Y/184/21/DOC – CONDITIONS 8, 9 AND 10: DRAINAGE RESPONSE

Thank you for returning comments from your Drainage Engineer pertaining to planning conditions 8, 9 and 10 under planning permission Y/184/21/DOC for the Crematorium, Bognor.

Job Title **Central Arun Crematorium**

Project No.	Originator	Volume	Lvl/Loc	Type	Role	Number	Rev
13591	CRH	XX	XX	DR	C	5304	P1

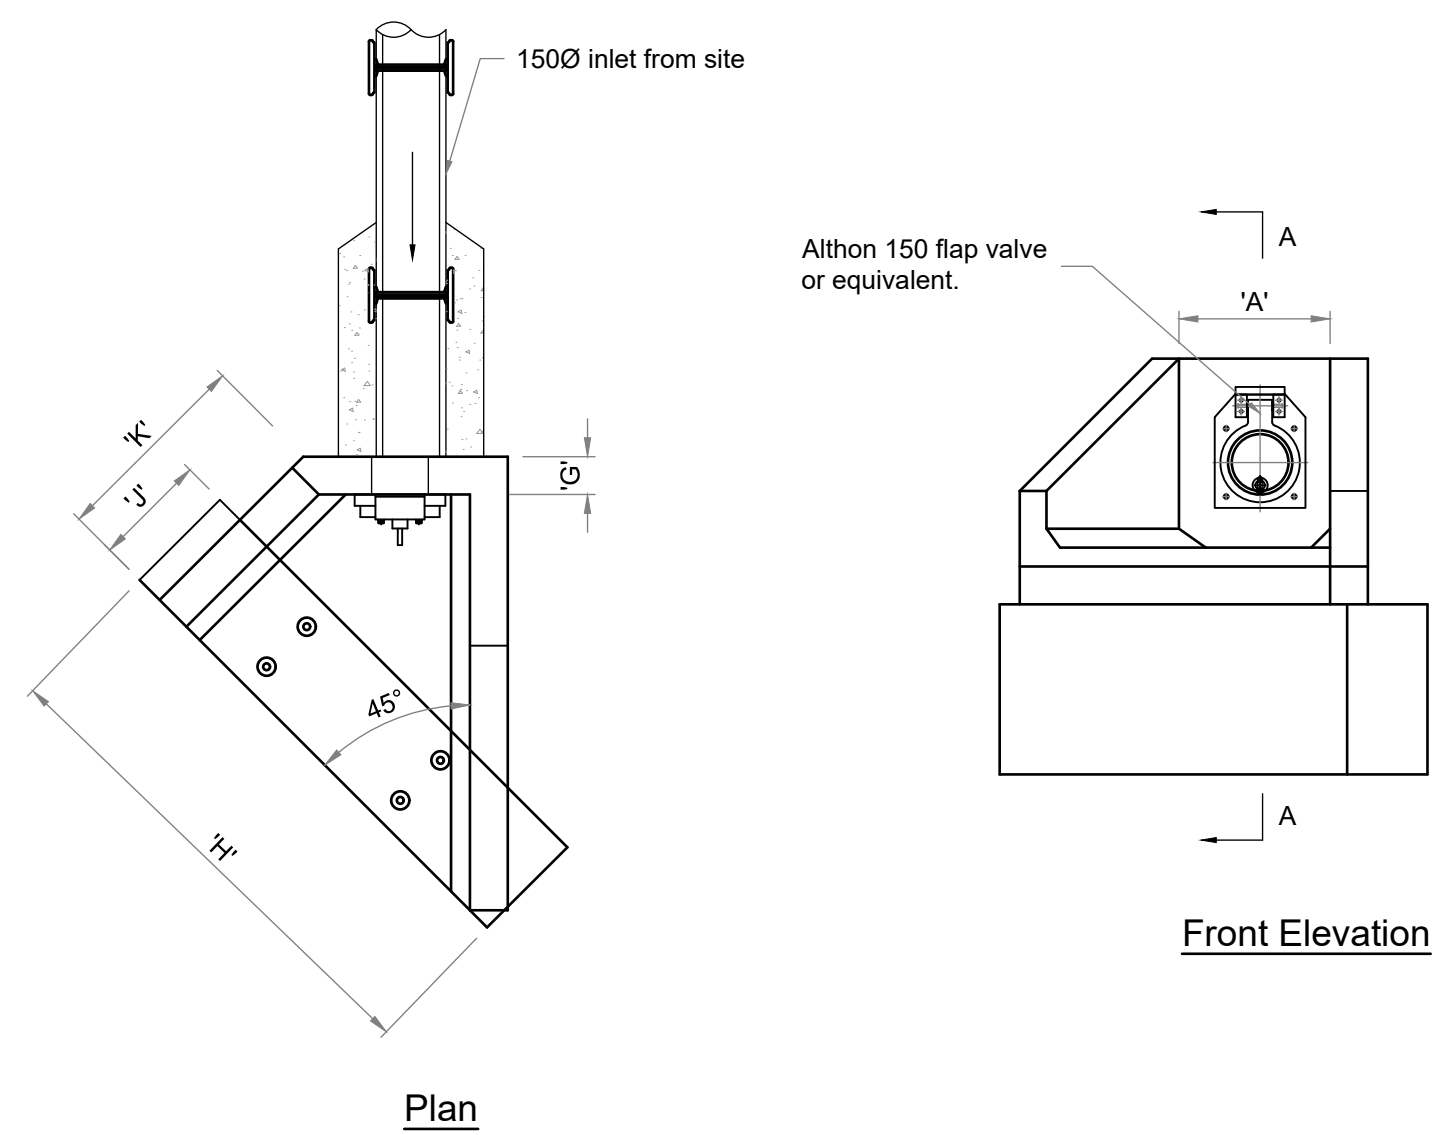
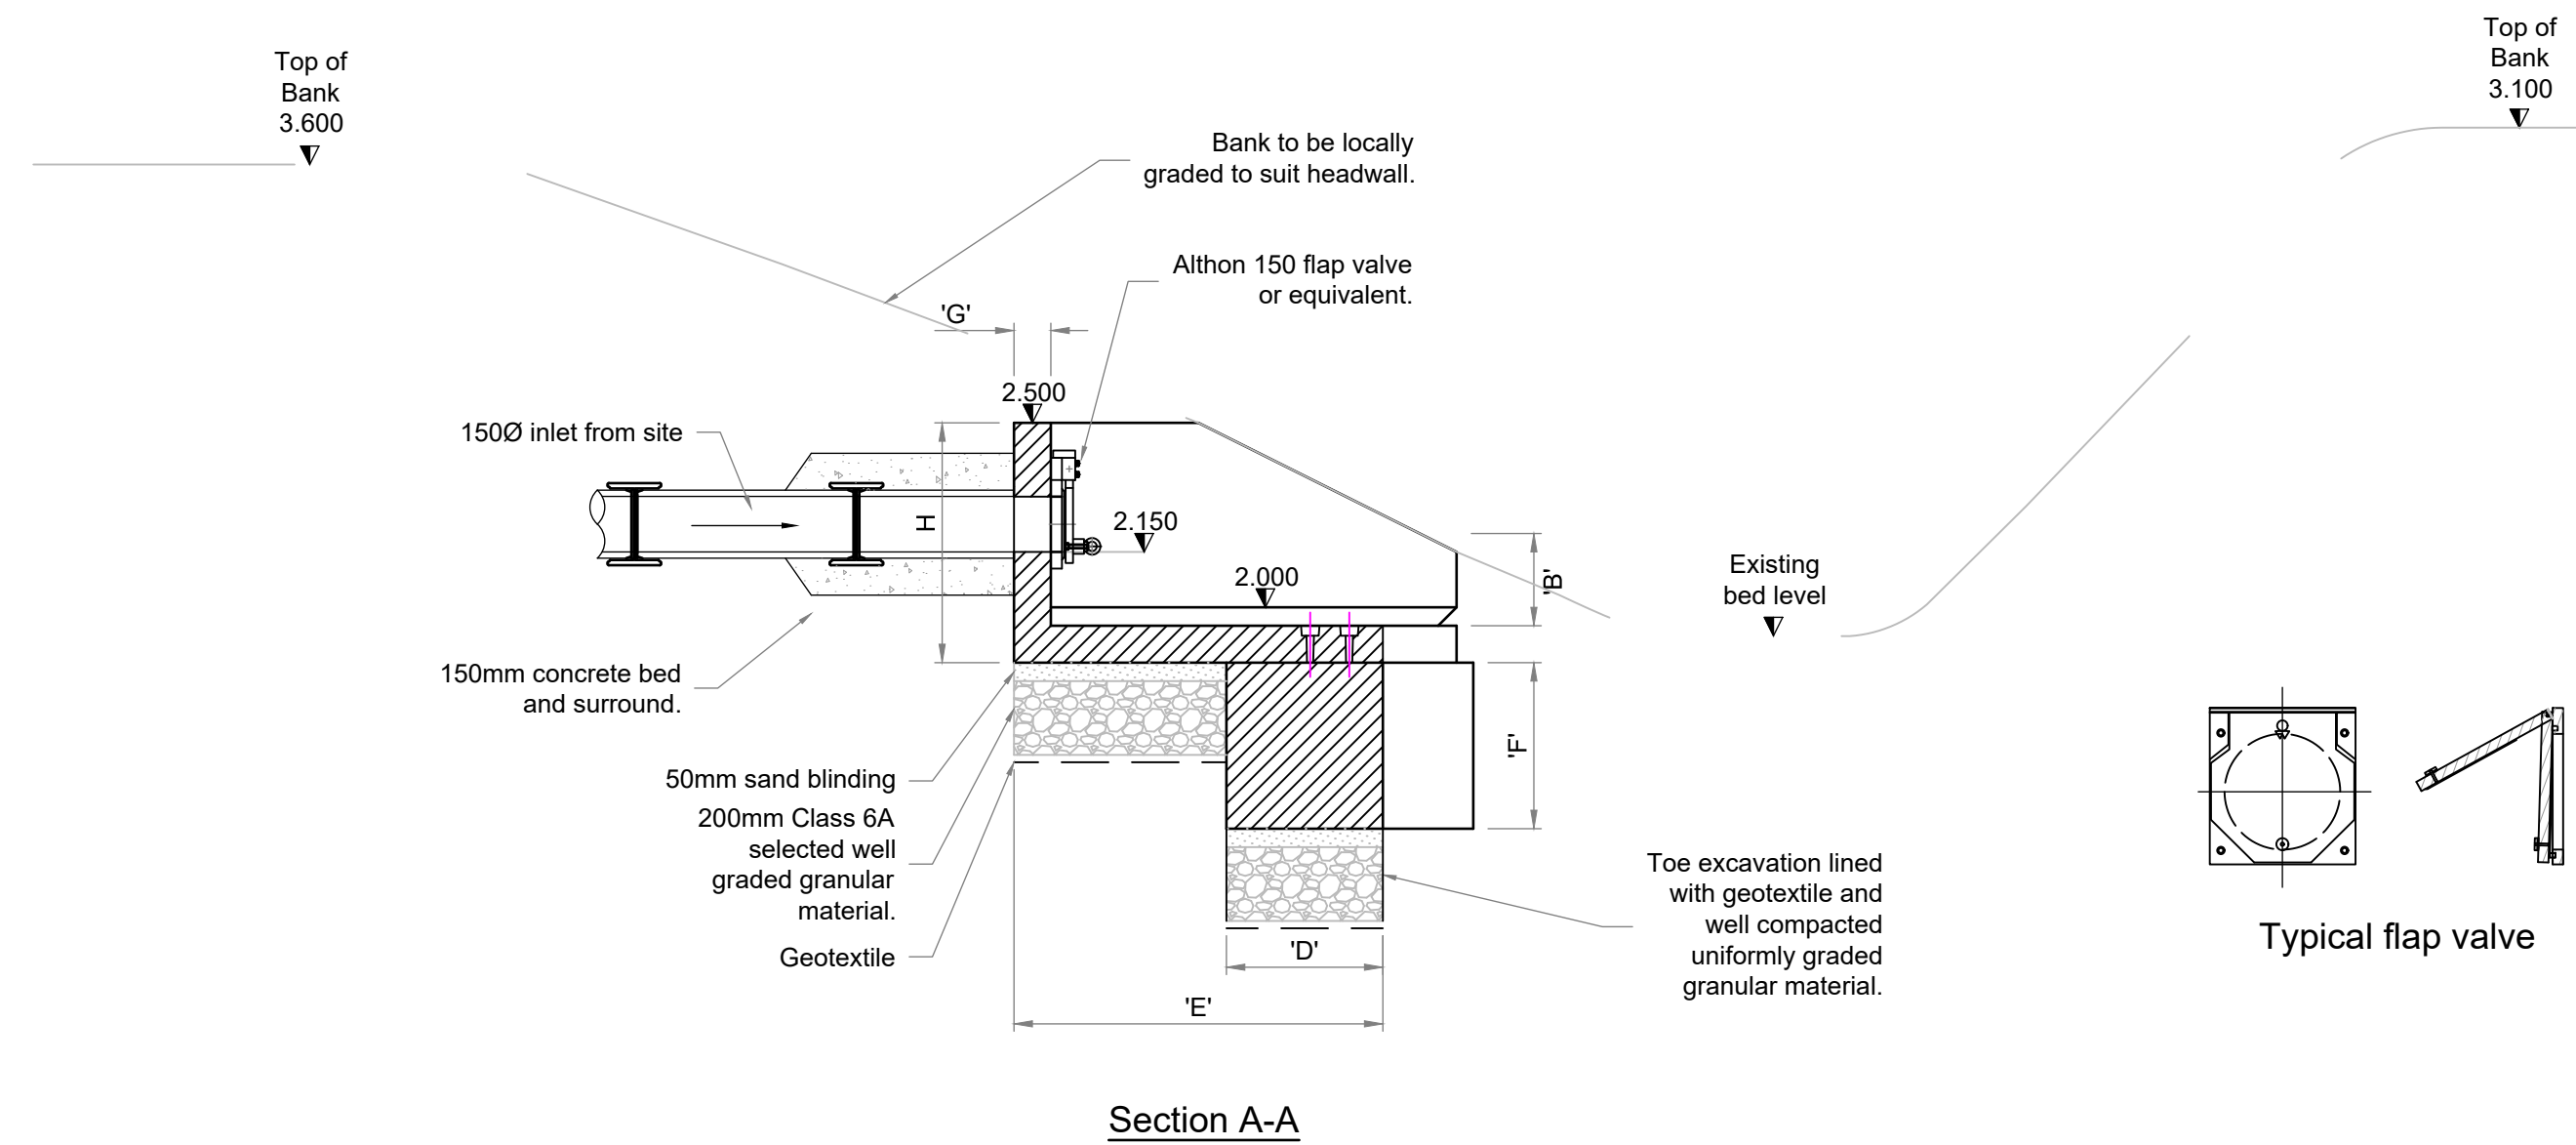
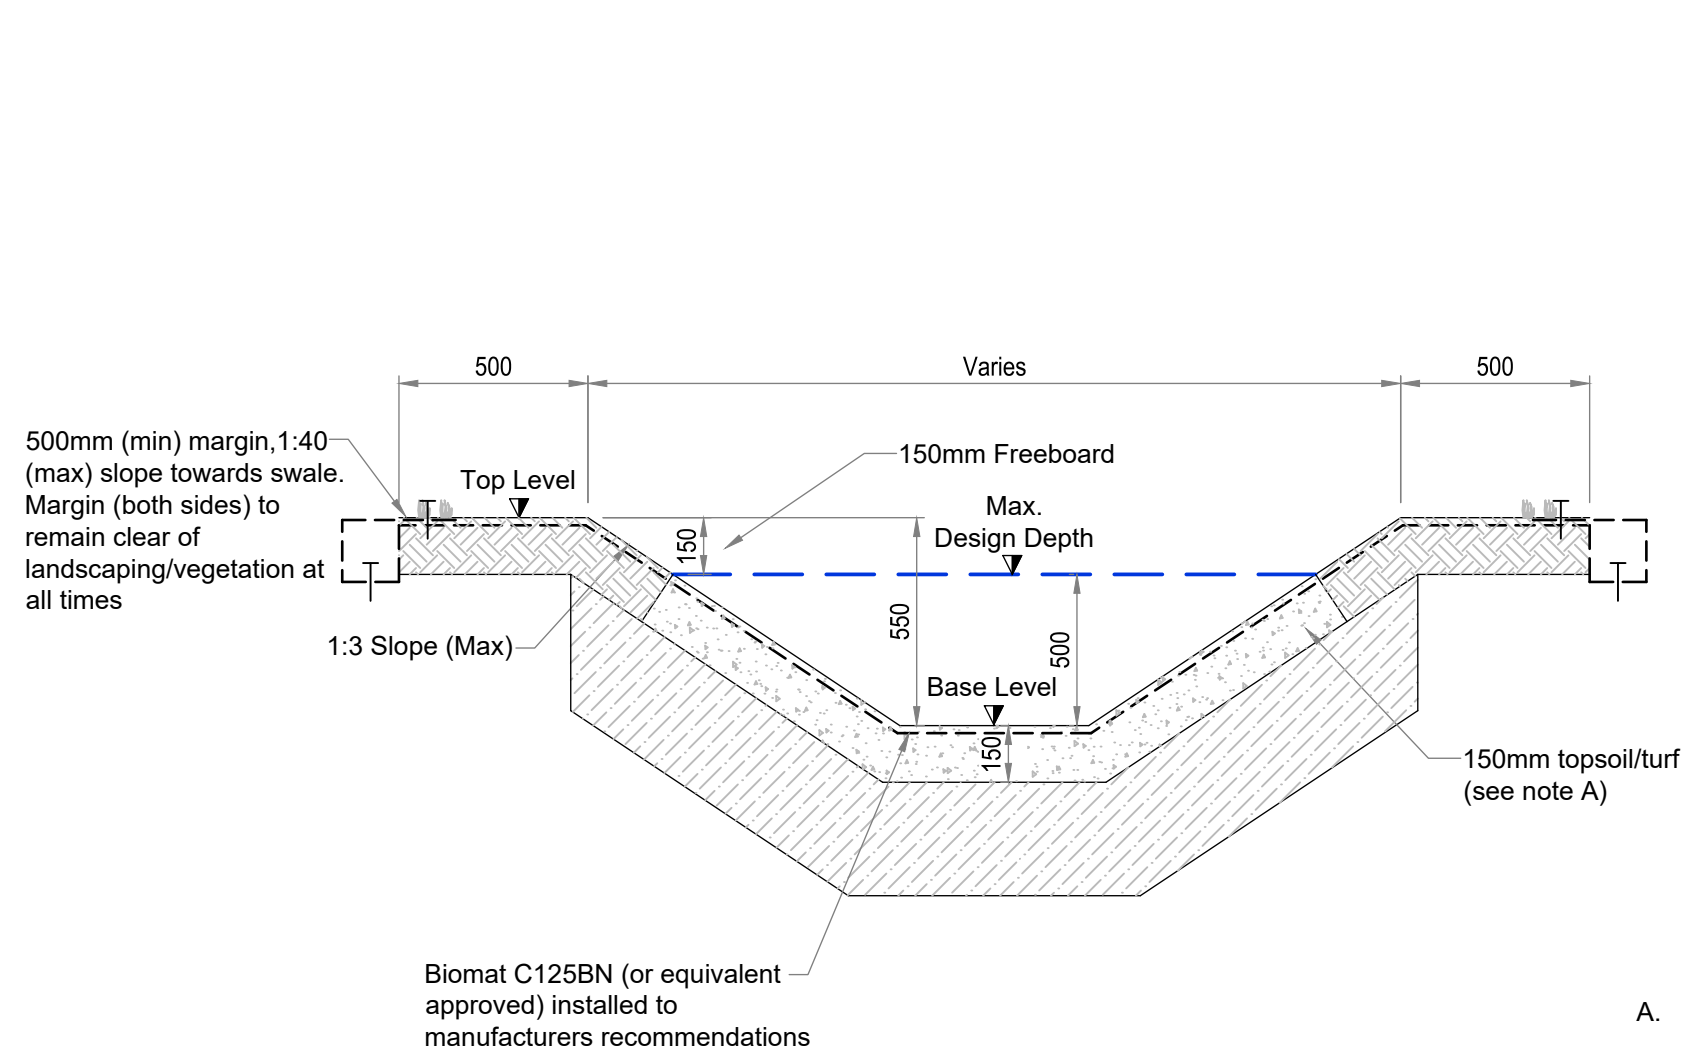
1. Please supply evidence of consent applications for the new ditch, and headwall to the existing ditch.
2. Please supply a buffer plan to show that at least 3m is being provided between top of bank of watercourses and obstructing features, such as fences, buildings, and basins.

1. OWC application for the discharge headwall from the basin was formally submitted in September 2021 together with all information requested by Paul Cann as per his email of 11th August 2021. Referring to Land Drainage Act 1991 Section 23(3), could you please confirm when consent letter will be issued?
2. The OWC consent for the new ditch is as shown on the attached consent (Consent Number LDC/ARUN/2021/015)
3. A suitable buffer has been provided between top of basin and edge of watercourse to allow for maintenance, as shown on drawing *13591-CRH-XX-XX-DR-C-5051 Revision P5*.
